Subject: Request for Individual Permit Modification for NC 16 from north of SR
1386 in Lincoln County to North of SR 1895 in Catawba County. Federal
Aid Project No. STP-F-24-1(34) State Project No. 8.1830501. \$475.00
Debit work order 34383.1.5. TIP Project No. R-2206C.

Reference: USACE Individual Permit dated October 7, 2004, Action ID 200420899.
NCDWQ Water Quality Certification dated September 21, 2004,
Individual WQC No. 3476.

The purpose of this letter is to request modifications to the Clean Water Act (CWA) Section 404 Permit issued by the USACE and the 401 Water Quality Certification issued by the NCDWQ. This project is currently under construction. The North Carolina Department of Transportation (NCDOT) is proposing modifications to Station 199+30 (Killian Creek Bridge) (1) and Permit Site 17 (Station 20+00) (2), after the fact, and to Station 256+70 (Reed Creek Bridge) (3) and Permit Site 15C (Station 266+40) (4).

PROJECT REFERENCE NO. R-2206C		SHEET NO. 10	
R/W SHEET NO.			
ROADWAY DESIGN ENGINEER KEITH C. NIELSEN DB 770 PG 81		HYDRAULICS ENGINEER KENNETH F. CARPENTER DB 896 PG 355	
CONST. REV.		R/W REV.

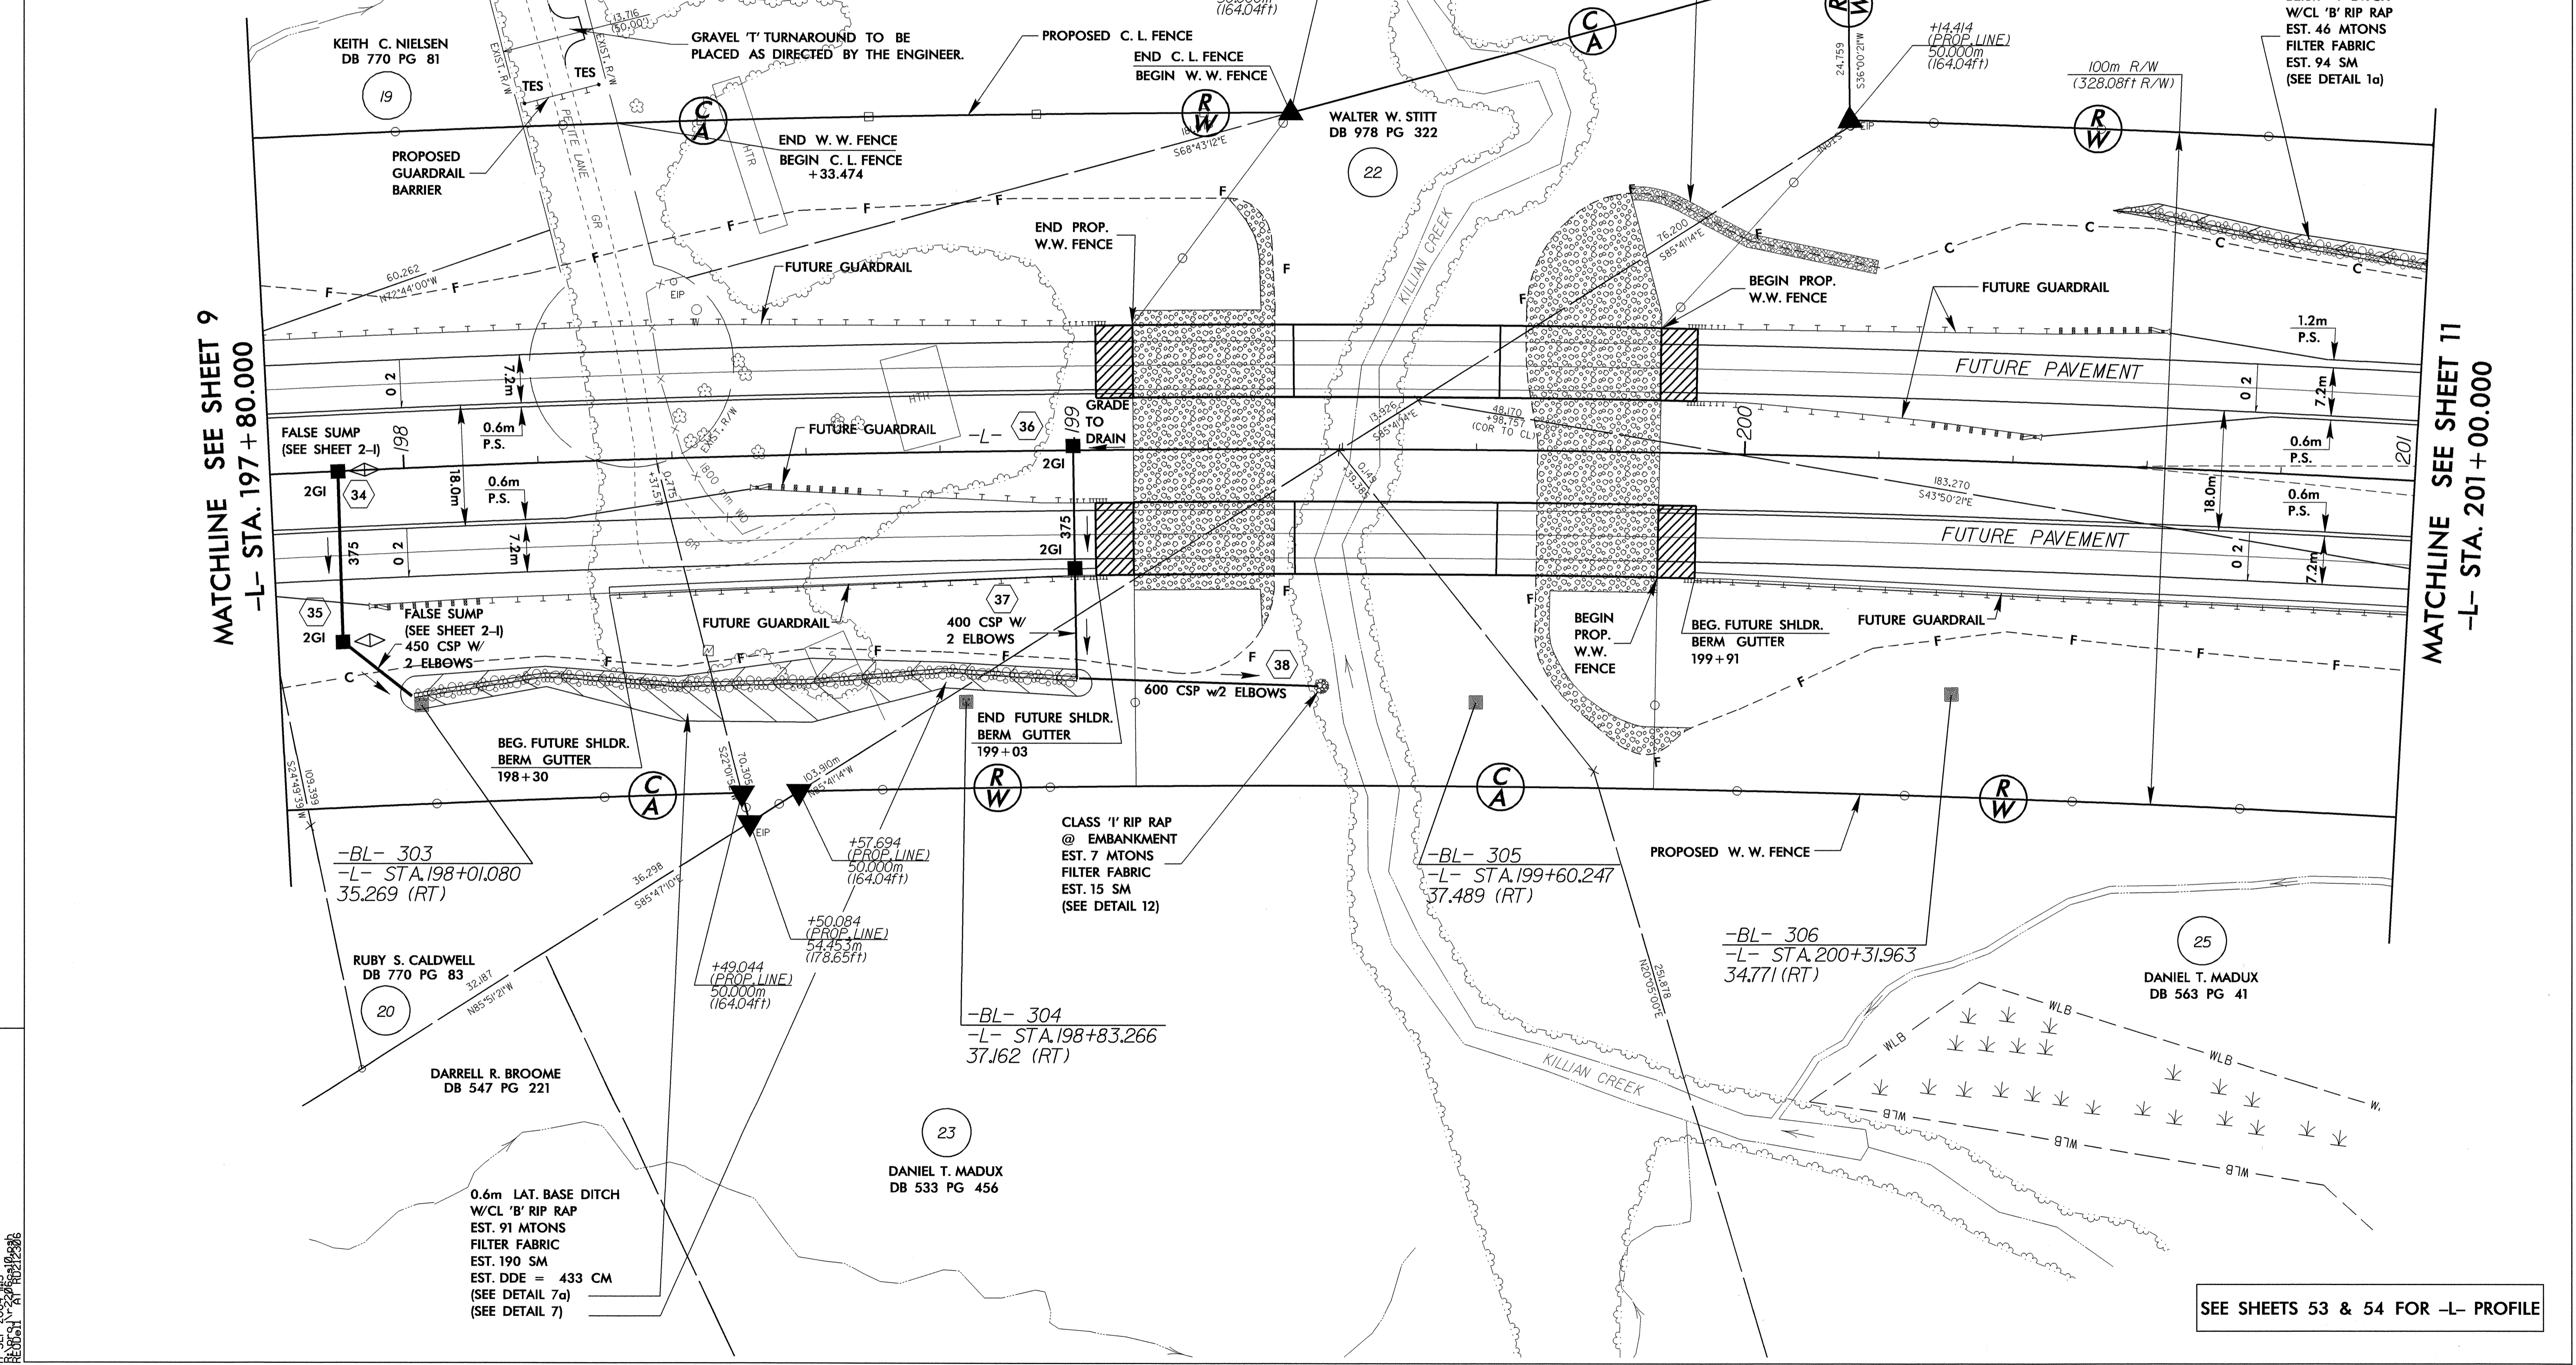
- (1) Killian Creek Bridge requires bank stabilization at the new bridge supports due to erosion (see enclosed photo). Rock has already been installed in a "stair-step" fashion from existing water's edge to top of bank. Stream width dimensions and bankfull width dimensions maintained based upon upstream reference cross-section (enclosed). The permanent impacts for this are 70 linear feet.
- (2) Unpermitted wetland fill impacts in the vicinity of permit site 17C total 0.09 acre.
- (3) Reed Creek Bridge requires bank stabilization at the new bridge supports due to erosion (see enclosed photo). Rock will be installed in a "stair-step" fashion from existing water's edge to top of bank. Stream width dimensions and bankfull width

dimensions maintained based upon upstream reference cross-section (enclosed). The permanent impacts for this are 65 linear feet.
